**Consultation Response from KC,
Ecology Unit**

2021/93689 Land to the south of, Ravensthorpe Road / Lees Hall Road, Dewsbury

Responding Officer: Gareth Hey

Legend

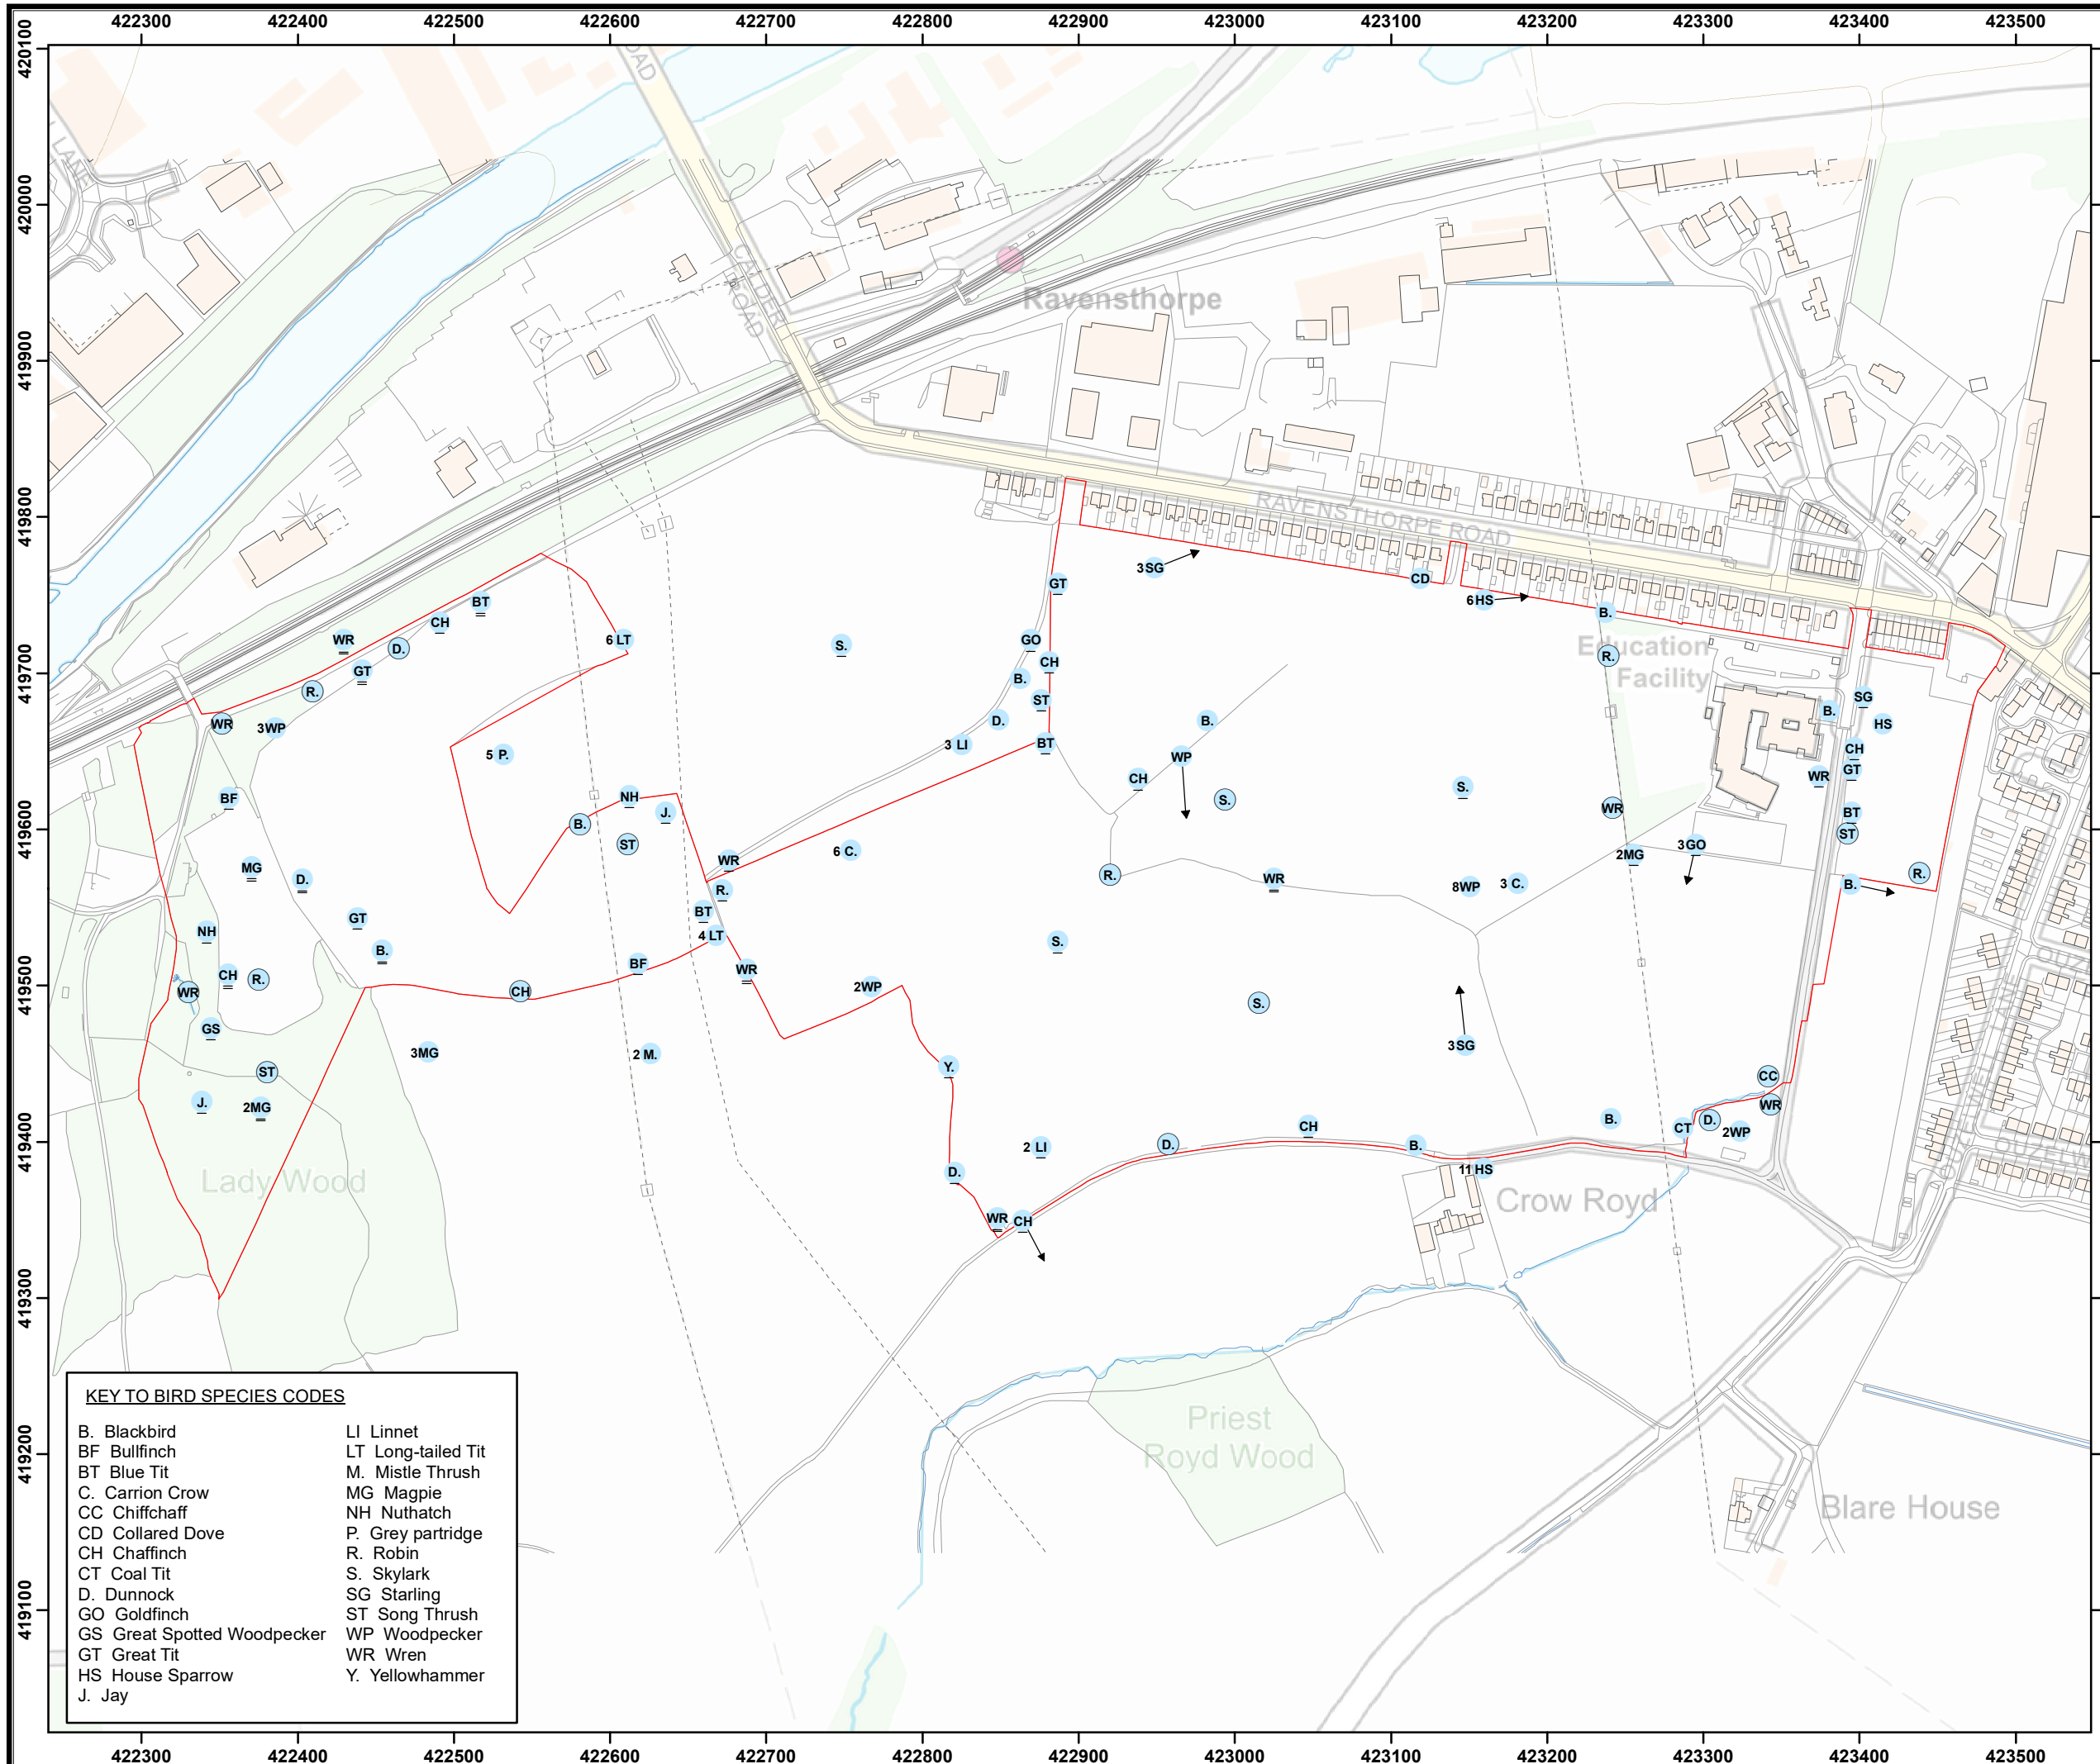
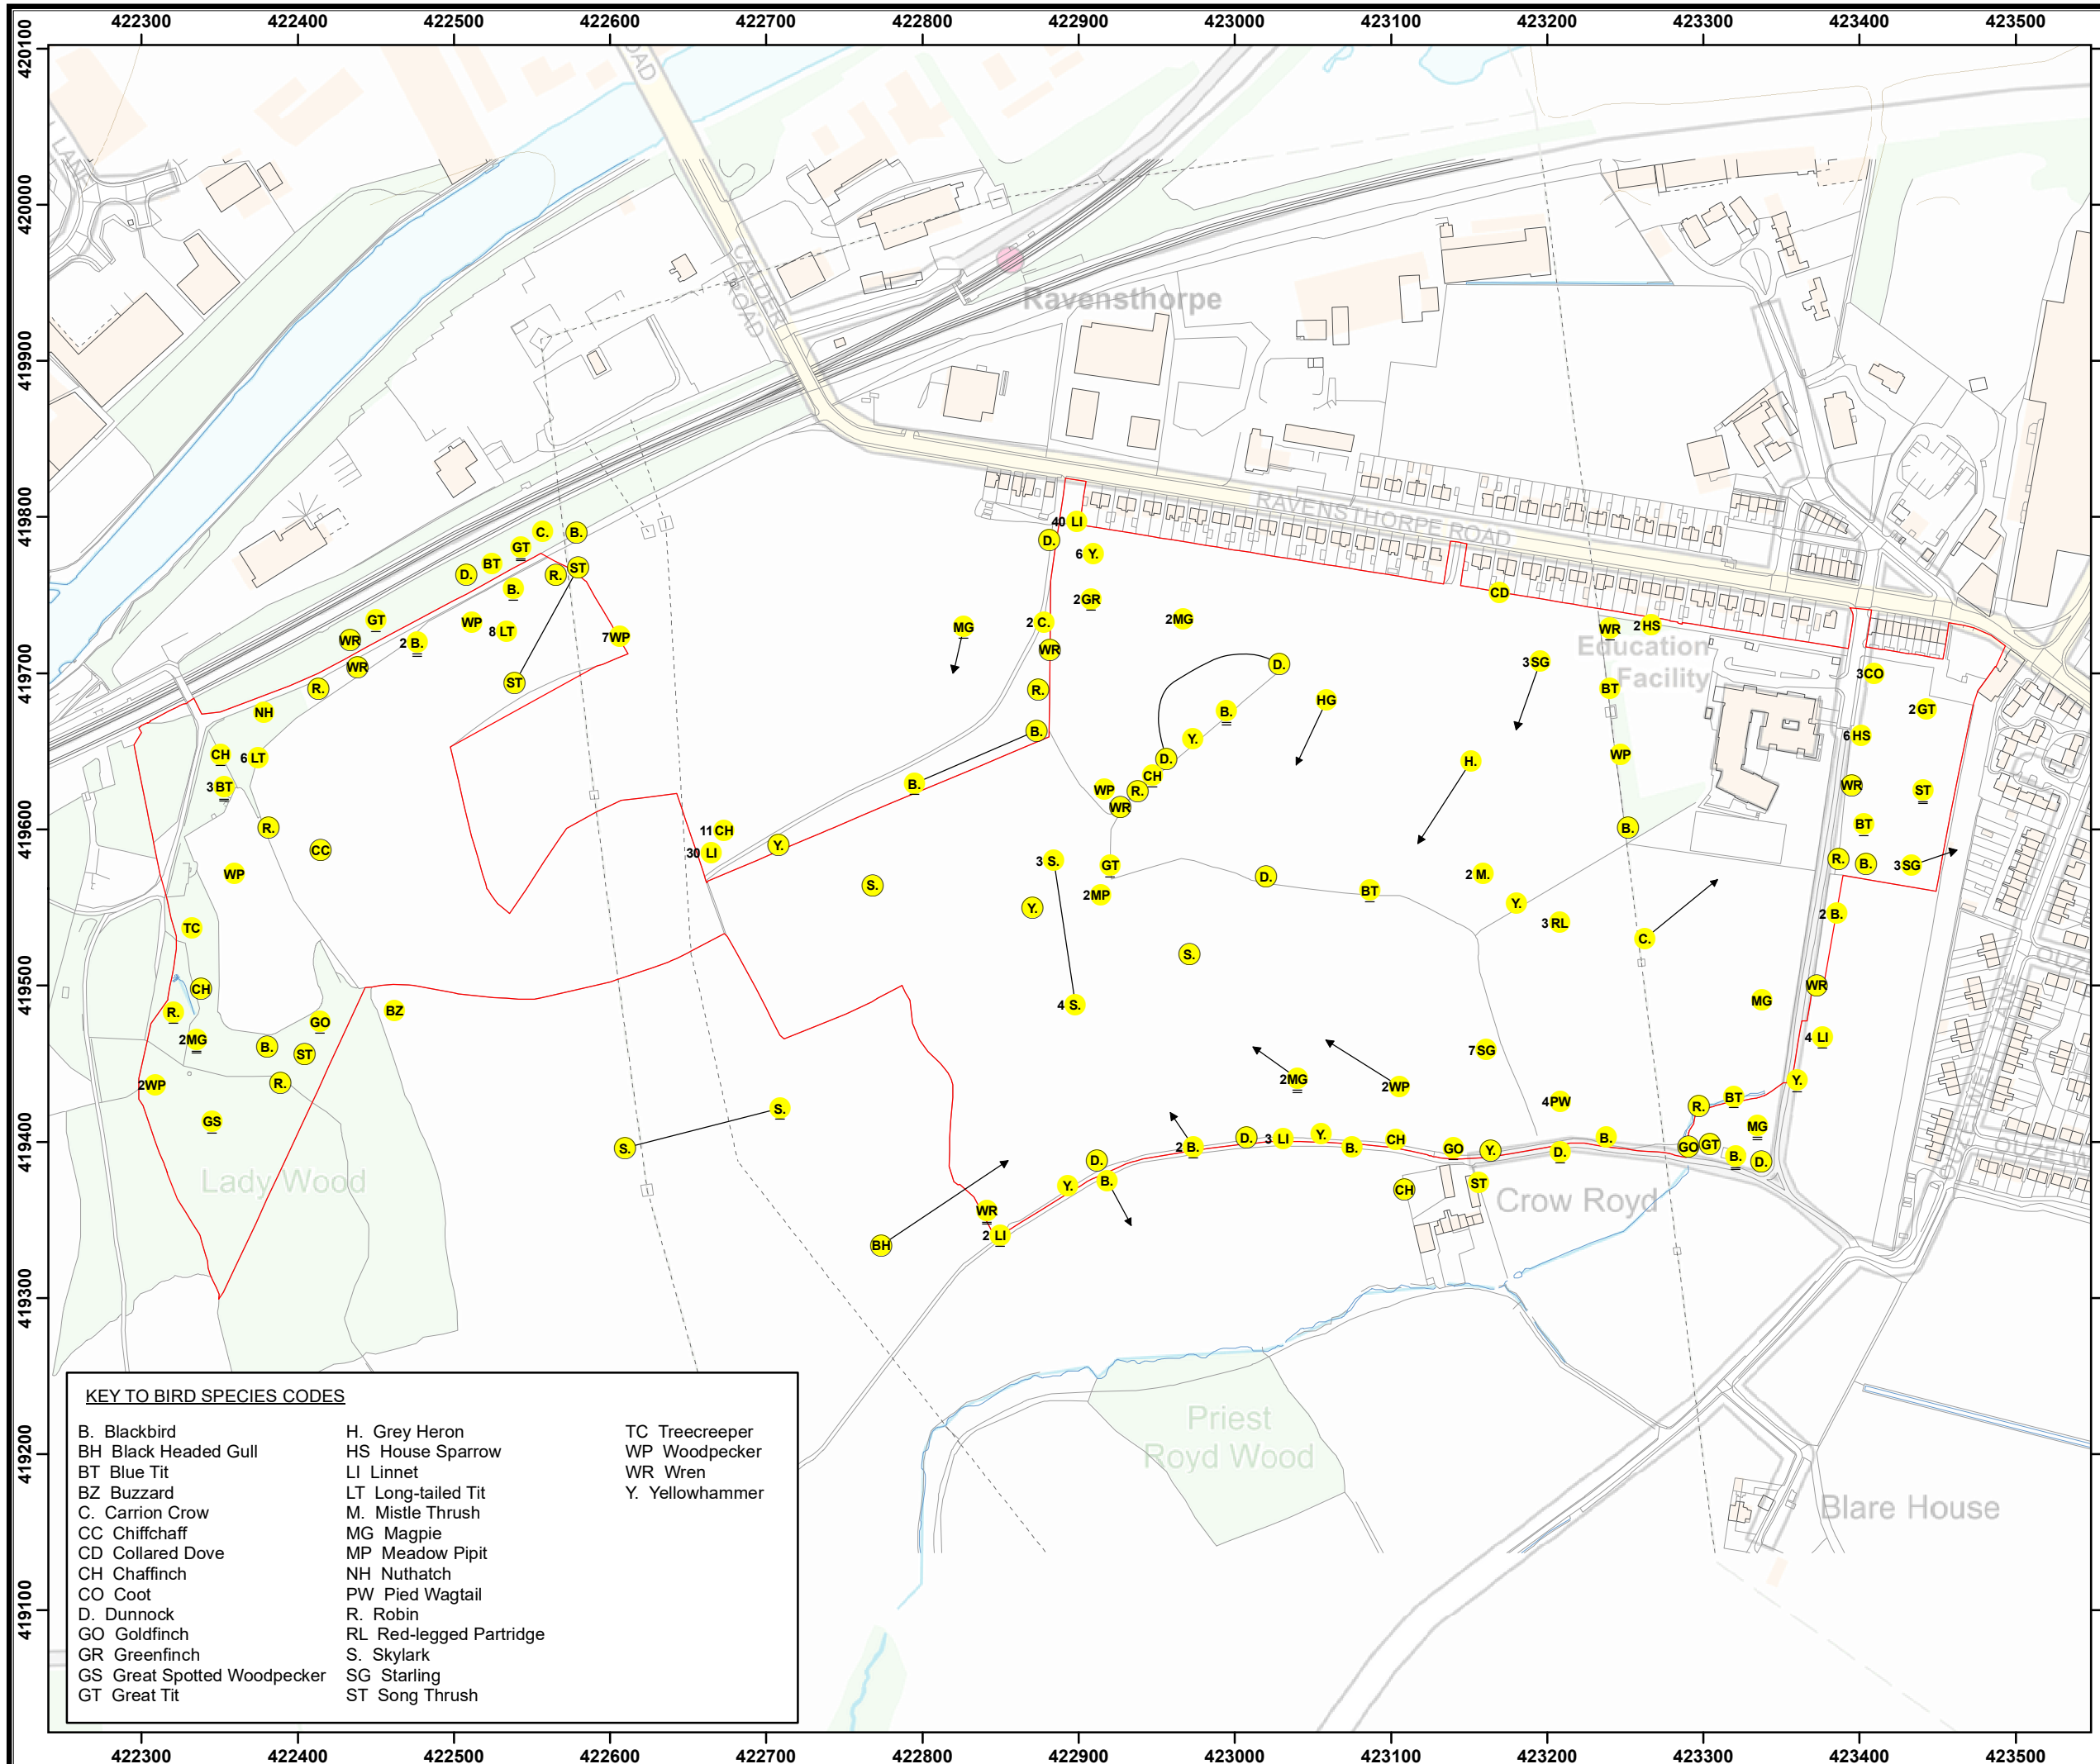
No information regarding wintering bird species has been provided as part of the EclA. Given the habitats present on site and connections to other areas of suitable habitats within the area, information relating to wintering bird species should be provided prior to determination.

- **Detailed roosting survey report including presence/absence surveys on buildings to be demolished for access.**
- **Badger survey report to be submitted including sett monitoring and territory analysis.**
- **Wintering bird survey information to be submitted to determine the sites suitability for wintering birds and if additional surveys are required.**
